## OFFICIAL NOTIFICATION OF DECISION

**Project# PR-2024-010329**

**PLT-2025-00014 MINOR PLAT**

**LOT/TRACT 97B, MAP 34 TR 97B** zoned **R-A**,  
located at **2611 Rio Grande Blvd NW**  
containing approximately **0.9042** acre(s).  
**(G-12)**

**Plat for
Tracts 97-B-1 thru 97-B-3,
MRGCD Map No. 34
Being Comprised of
Tract 97-B, MRGCD Map No. 34
City of Albuquerque
Bernalillo County, New Mexico
May 2024**

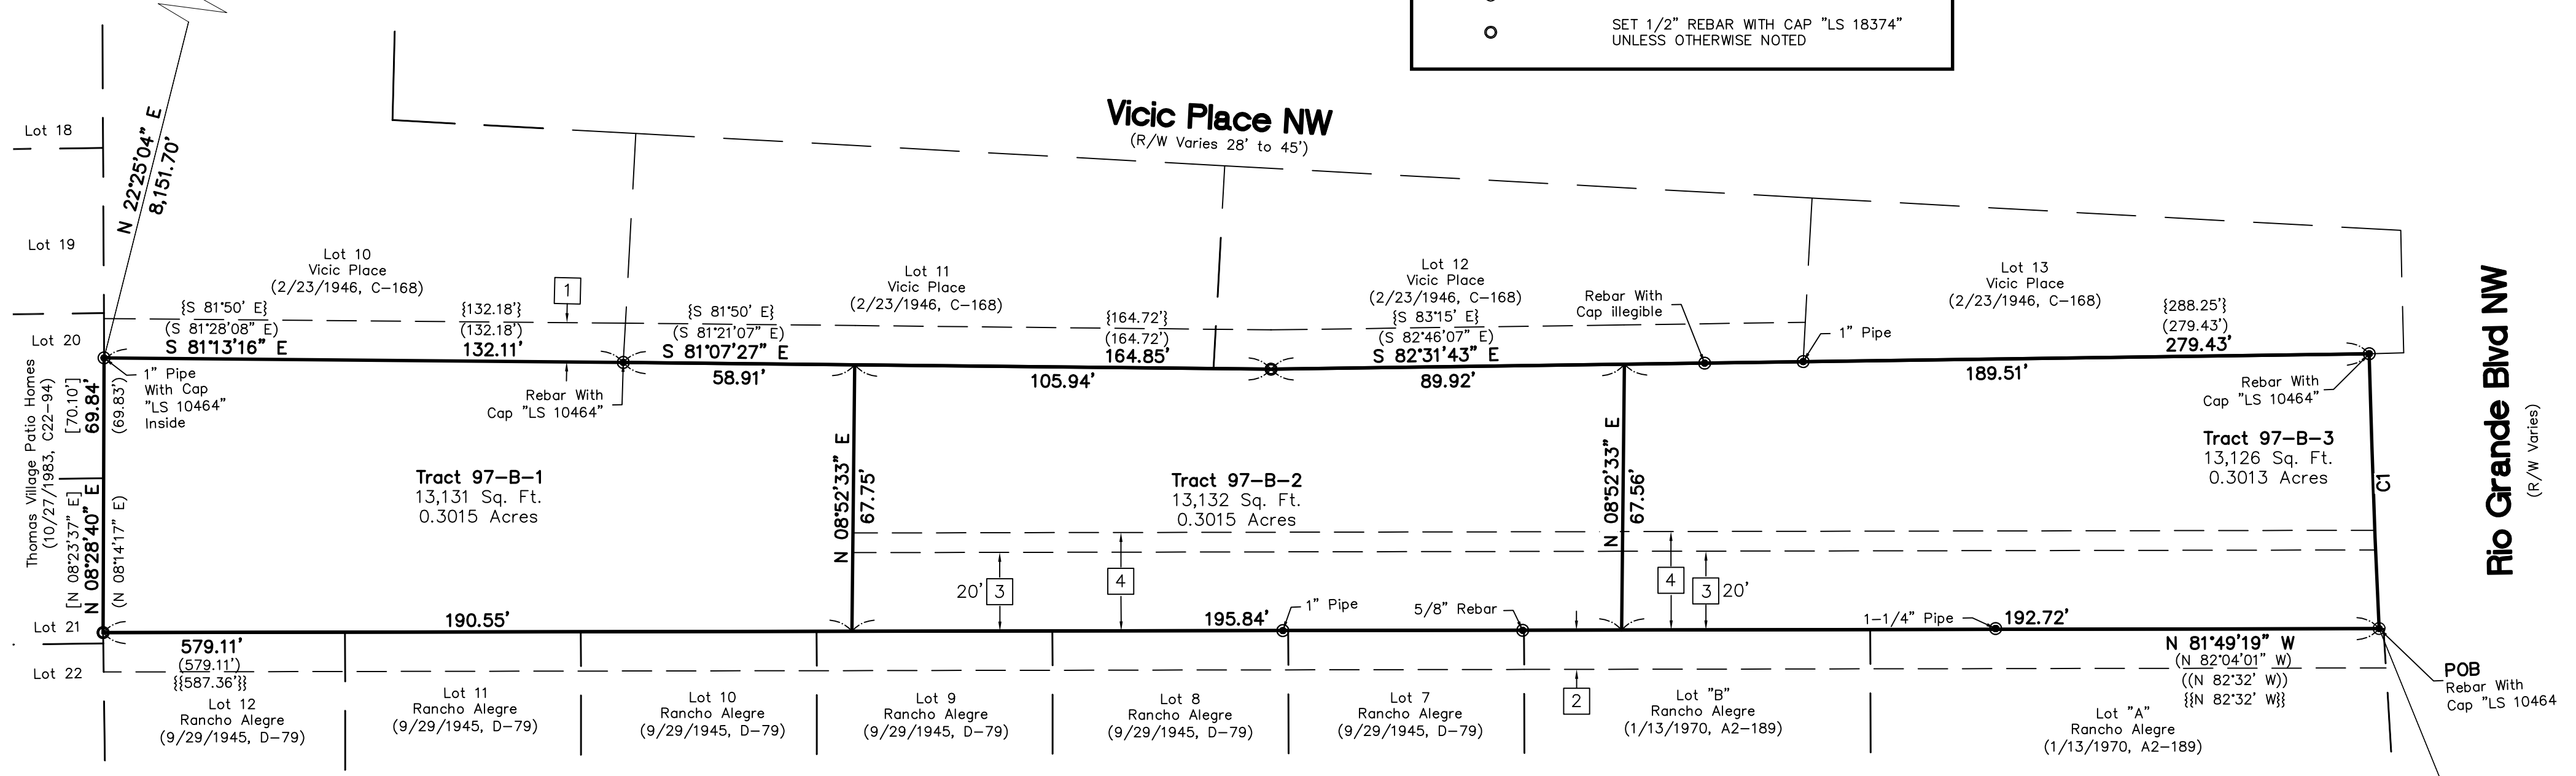
- f. Relocate the Water Authority easement general note to the cover sheet.
- g. Ensure each use of the easement adequately labels the easement as Public Water and Public Sanitary Sewer use.
- h. Coordination for a utility layout must take place for the proposed easement corridor prior to final sign off.

- i. Widen sidewalk to 6' and access easement to 22'.
